Your Ref :
Our Ref : P/10/19/NMA

Section 96A of the Town & Country Planning Act 1990 (as amended)
Town and Country Planning (Development Management Procedure) (England) Order 2015 (as amended) - Article 10

Non material amendment following the grant of P/4/18/PL to change from window to French doors in bedroom 2 (plot 2) & addition of velux window to second floor of plot 3.
The Coop, The Parade, Pagham,

PROJECT	Kings Beach	DATE	27/07/18
TITLE	Elevations Plot 2	DRG NO	IBA/505/09
SCALE	1 : 50	REVISIONS	C

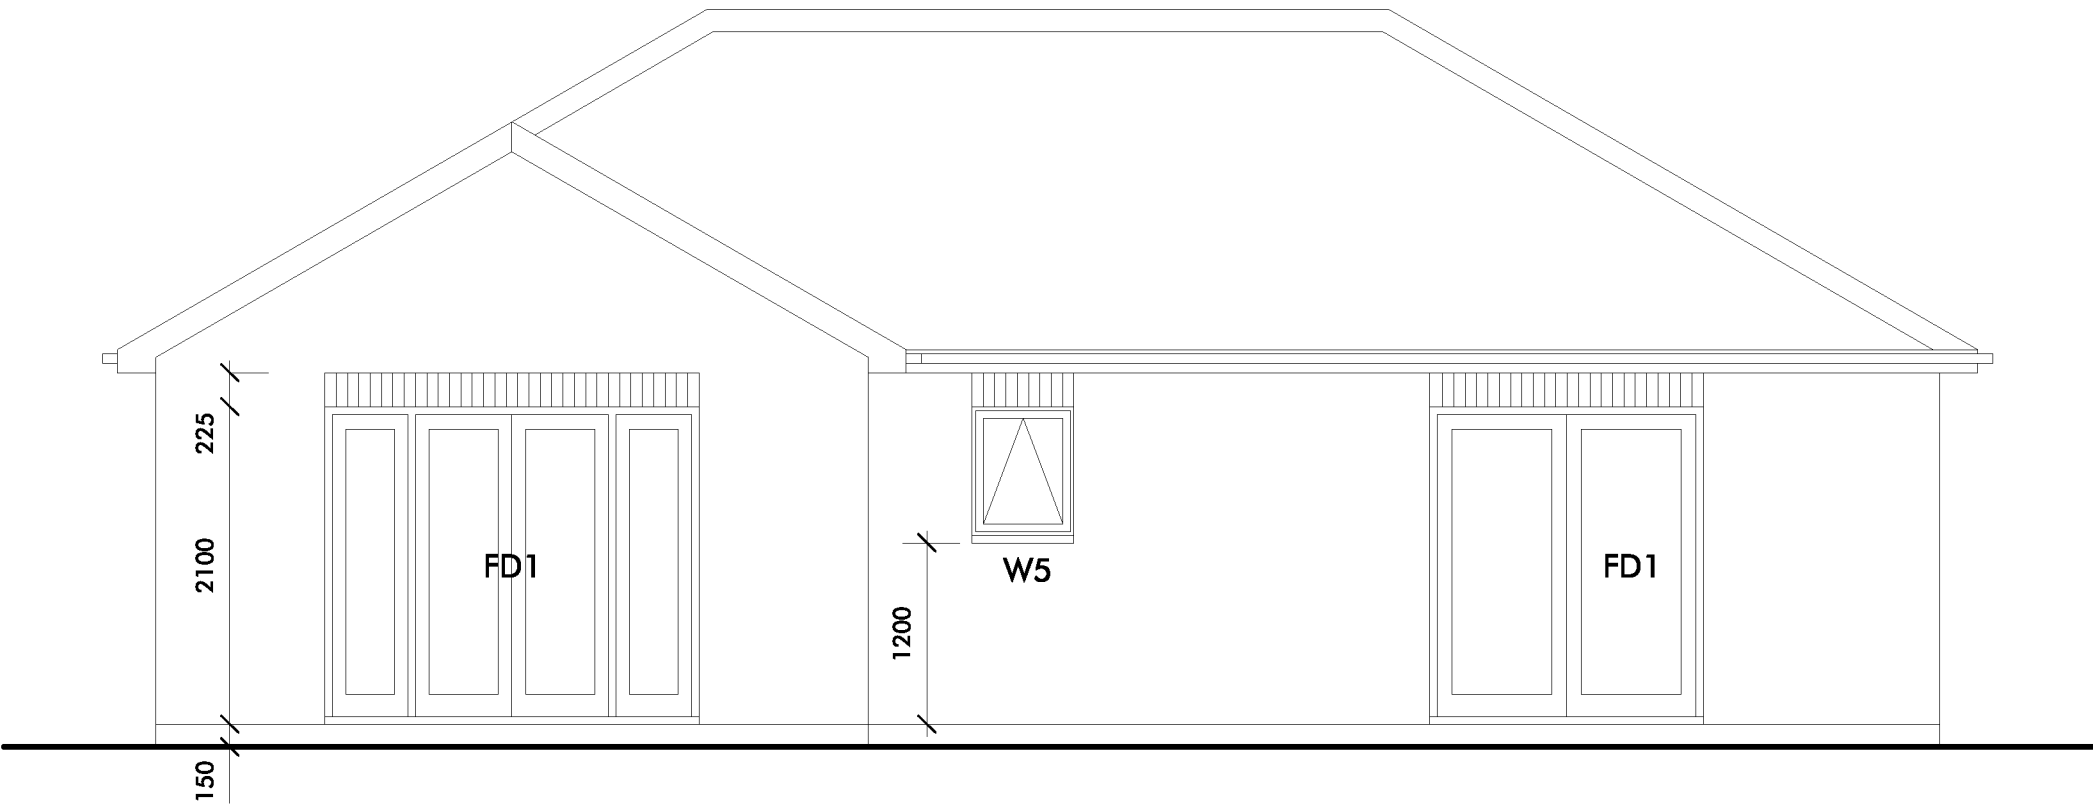
- (a) Change from a window to French doors to the 2nd bedroom on the rear elevation of bungalow 1 (now known as plot 1); and
- (b) Add a velux window to the front roof plane (second floor) of the plot 3 house.

IBA/505/04 Rev C (replaces 17.3030.103 Rev P1 Bungalow 1 Proposed Floorplans & Elevations);
IBA/505/09 Rev C (replaces 17.3030.103 Rev P1 Bungalow 1 Proposed Floorplans & Elevations);
IBA/505/07 Rev C (part replaces 17.3030.101 Rev P1 House 1 Proposed Floorplans - in respect of the second floor); and
IBA/505/10 Rev B (part replaces 17.3030.102 Rev P1 House 1 Proposed Elevations - in respect of the front elevation).
